**BOLTON-BY-BOWLAND, GISBURN FOREST & SAWLEY
PARISH COUNCIL**

OBSERVATIONS ON PLANNING APPLICATION

RELATING TO.....Stouks Hoek Bolton-BY BOWLAND

Application 3/2013/0134

Side Elevation

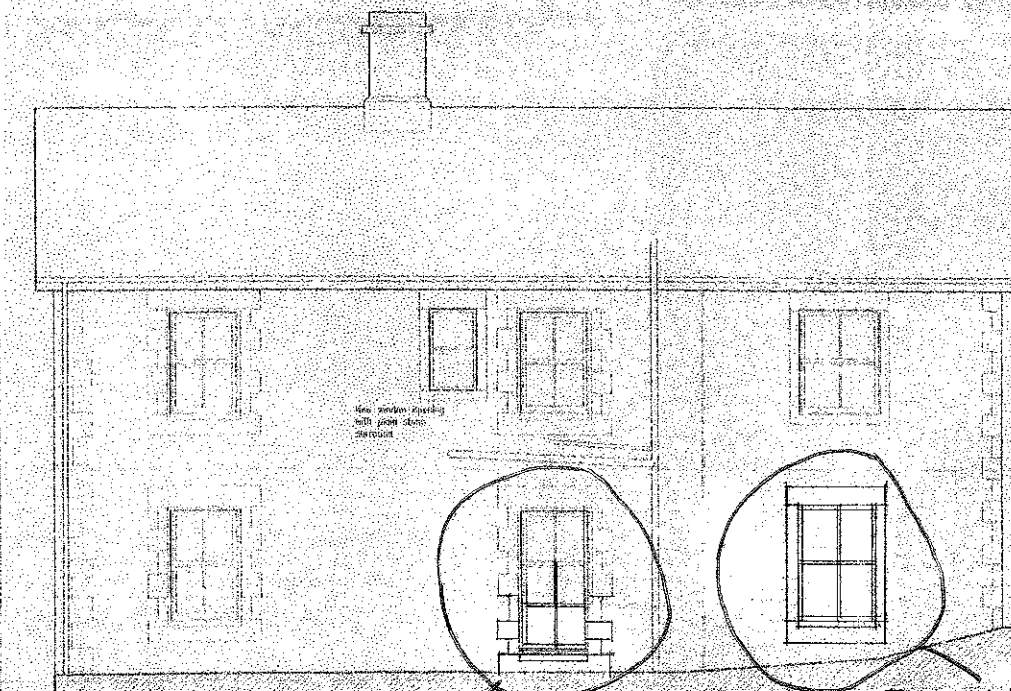
We are slightly bemused about lowering the window cill to 150 cm above ground. Is this to become a doorway? Will it be a 'french window'? Without knowing the exact reason for lowering the cill it is difficult to comment.

Rear Elevation

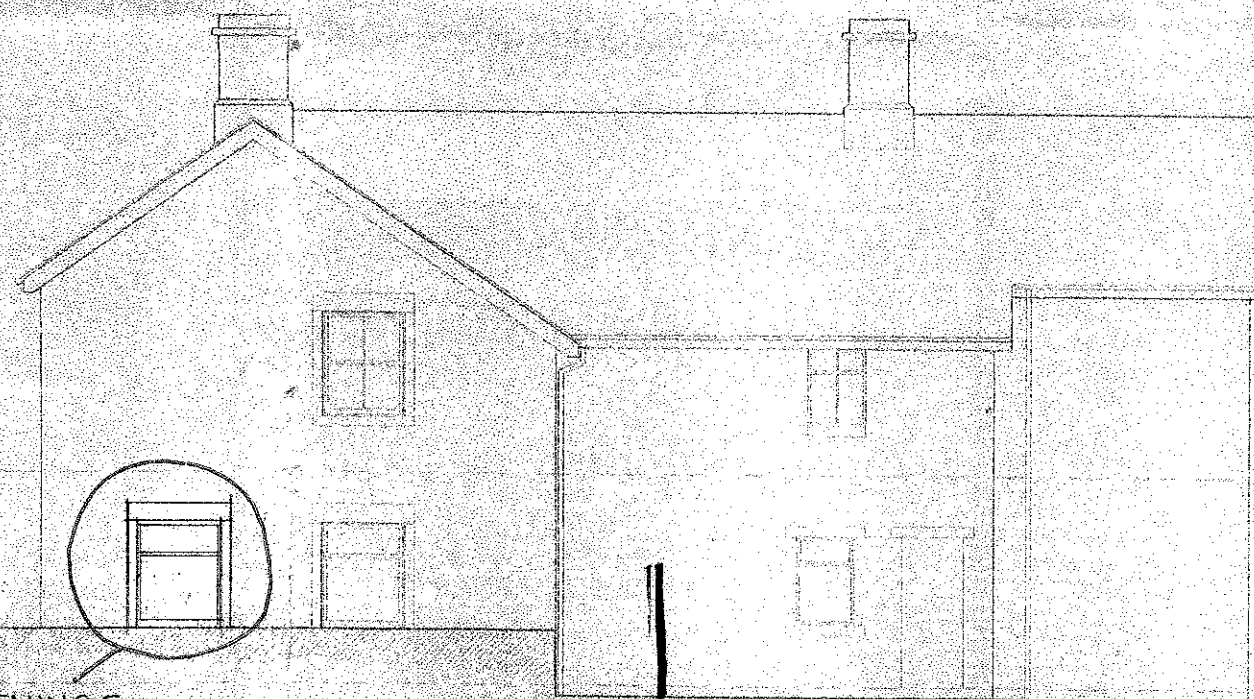
No objections to the new window openings. However, the style of window should match other windows on the same wall.
